#### **Portishead Branch Line (MetroWest Phase 1)**

Planning Inspectorate Reference: TR040011 Applicant: North Somerset District Council

#### 9.3.3 ExA.SoCG-EA.D6.V4 - Statement of Common Ground

Date: March 2021

Drawing Title: CATTLE CREEP PROPOSED GENERAL ARRANGEMENT SHEET 1 OF 2

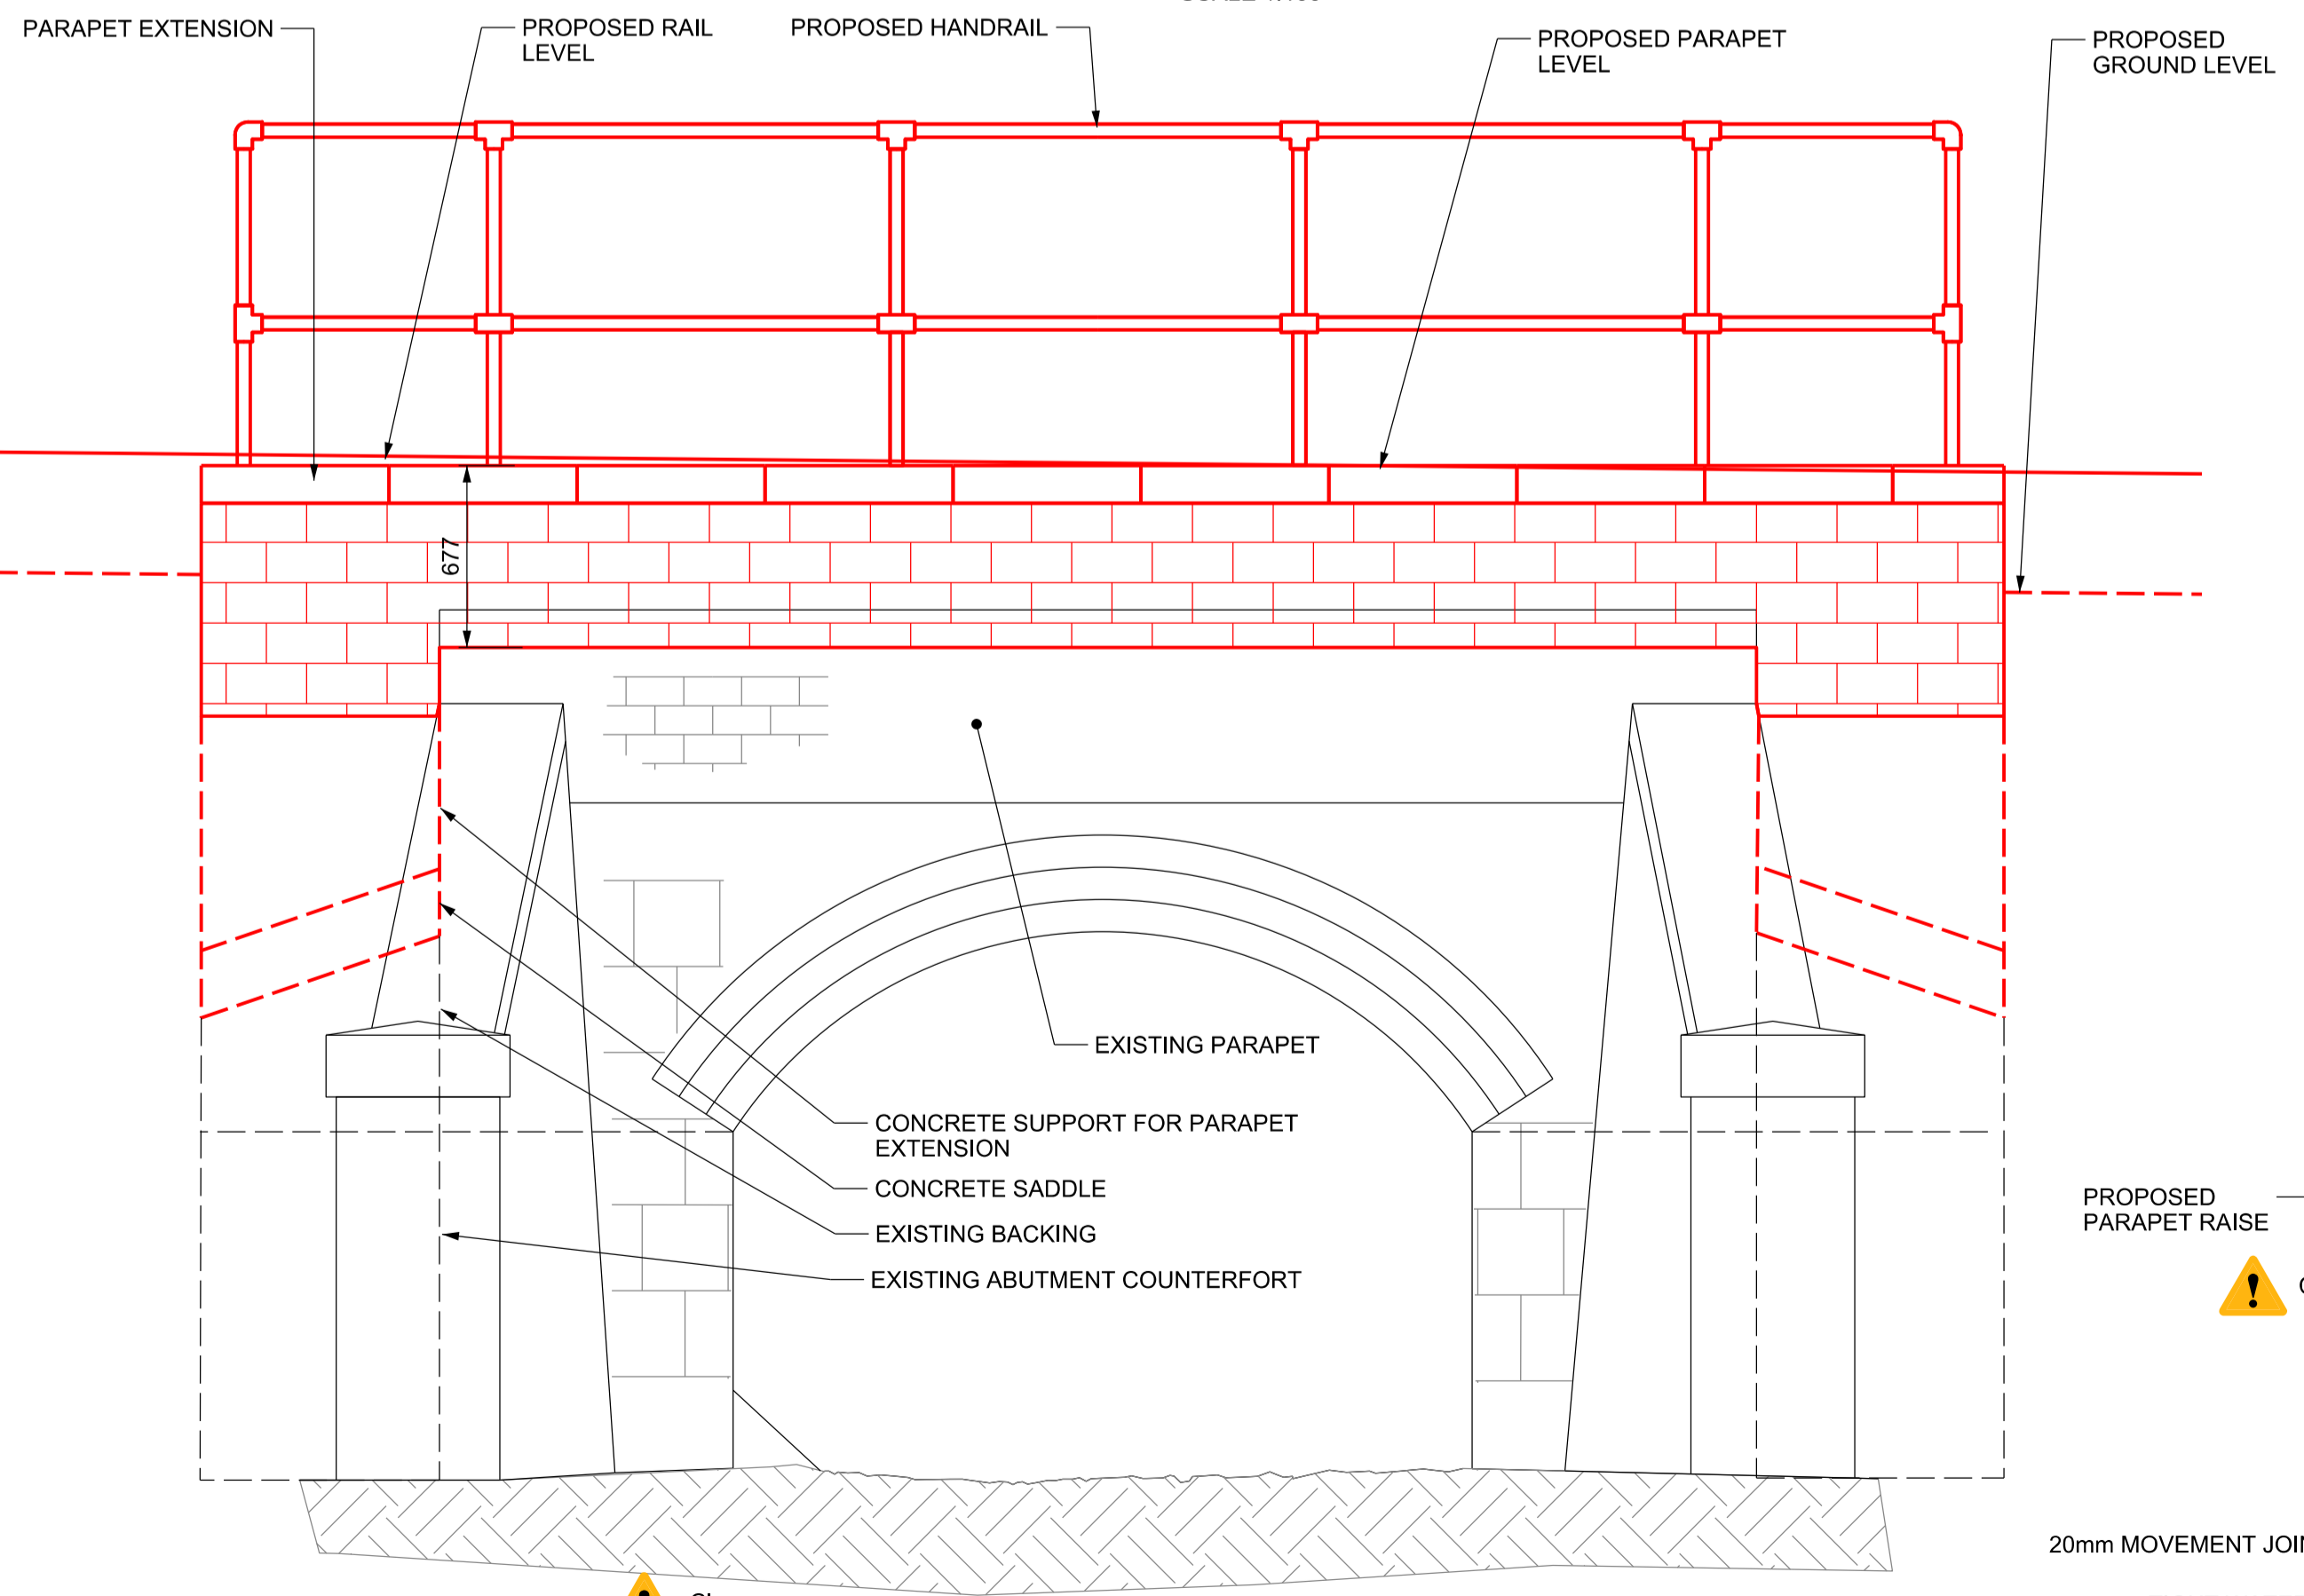
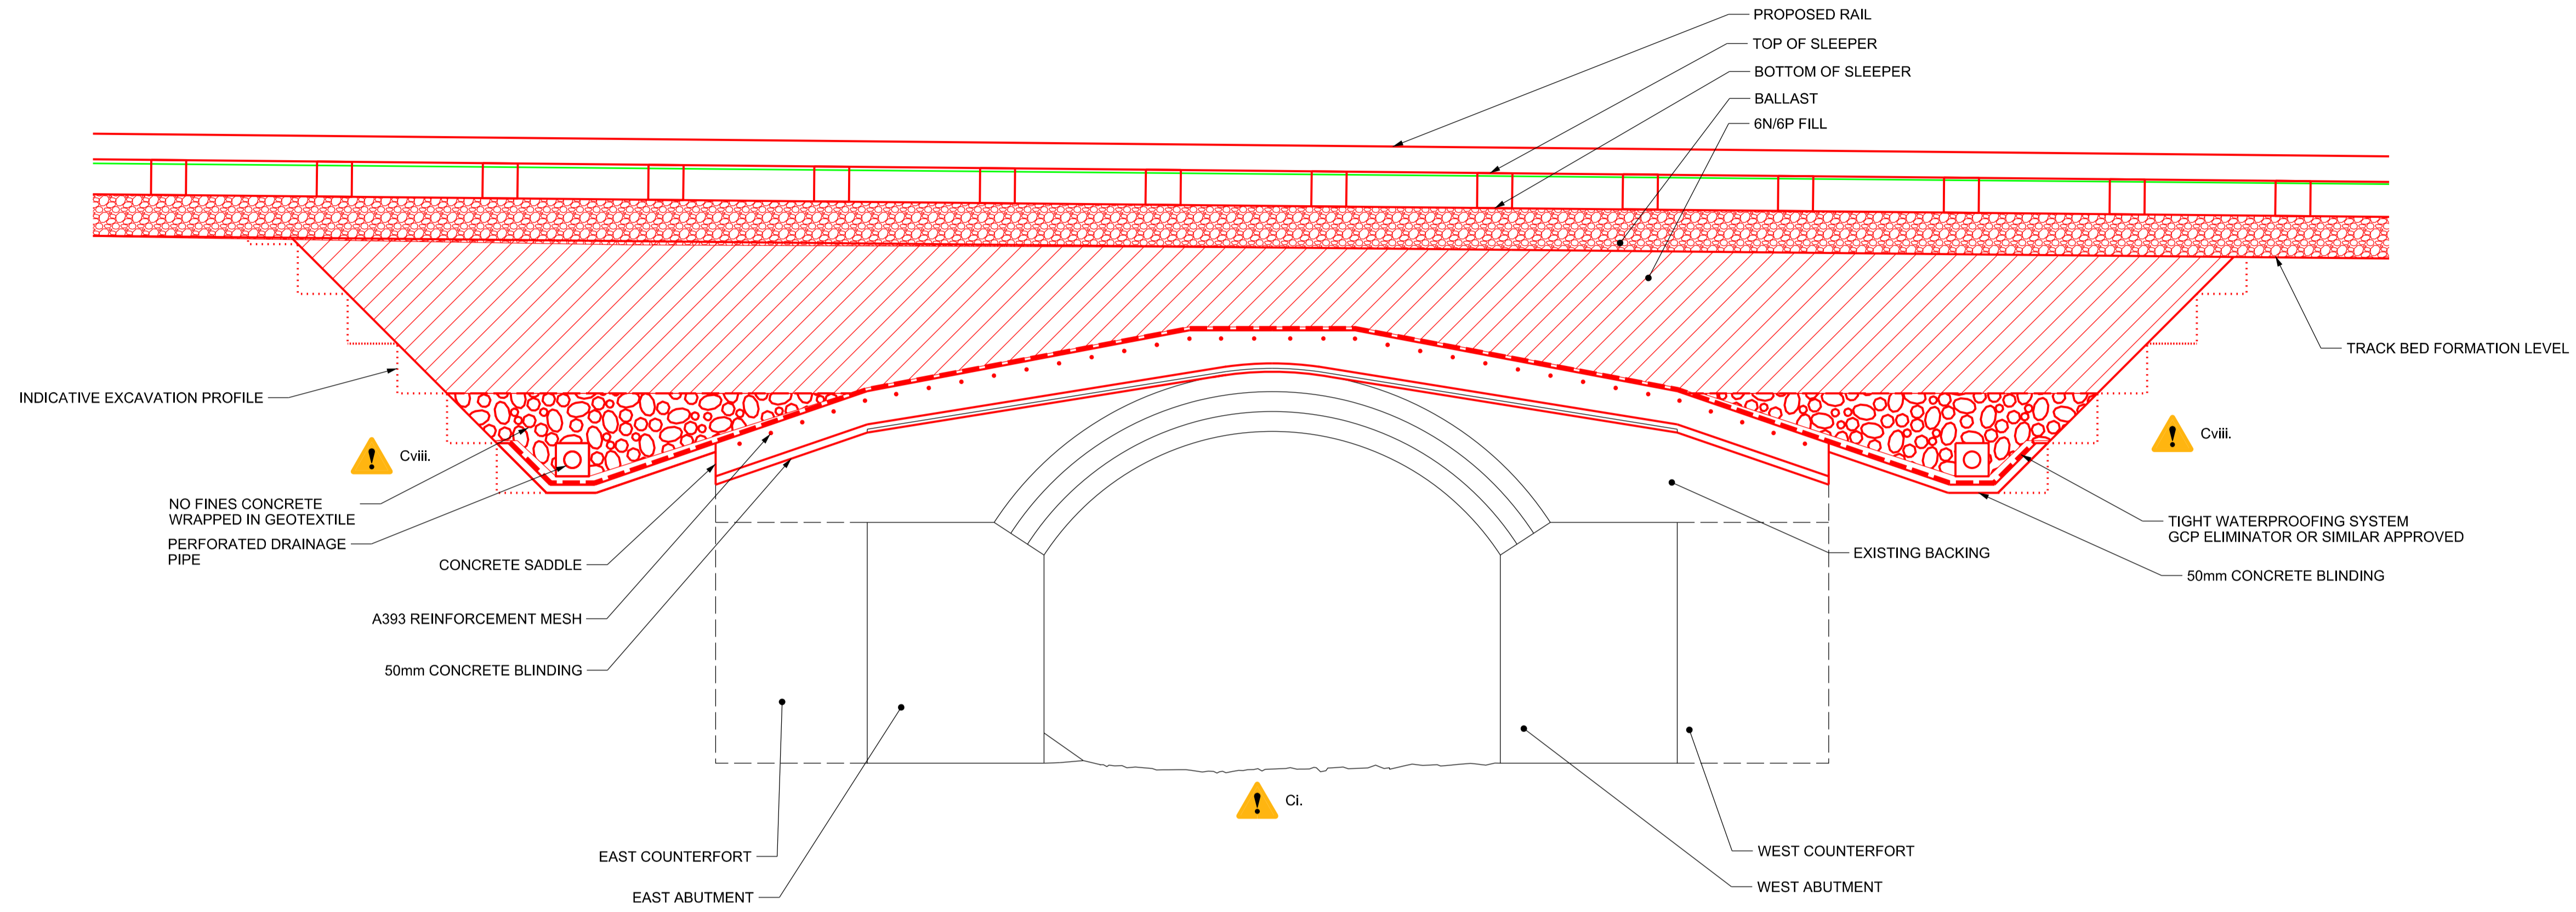
5.1.9	Easton in Gordano Stream	The EA agrees that specific flood compensation is not required however, this relies on a flood relief channel in the form of a farm access track running under the railway line. As a result, appropriate	There are no plans to block Cattle Creep access track and it will be maintained in its current form.	Issue Resolved; The EA has accepted a new requirement for Cattle Creep access track within the dDCO. as follows:  33.— (1) Work No. 1B must not commence before the undertaker has provided to the relevant planning authority and the Environment Agency a topographic	Deleted: Outstand Deleted: Applican Deleted: is consid Deleted: text

Ref	Topic	Environment Agency position	Applicant position	Status (Issue Resolved/Issue Outstanding)
		provisions are required within the DCO,		survey setting out the existing ground levels at Cattle Creep bridge, Easton in Gordano.  (2) Works to Cattle Creep Bridge must be carried out in accordance with the principles set out in the Cattle Creep Proposed General Arrangement drawing and in particular the arch of the Cattle Creep Underbridge must not be altered and the ground level beneath the Cattle Creep Underbridge must not be raised without the prior consent in writing of the relevant planning authority following consultation with the Environment Agency and (if relevant) the lead local flood authority
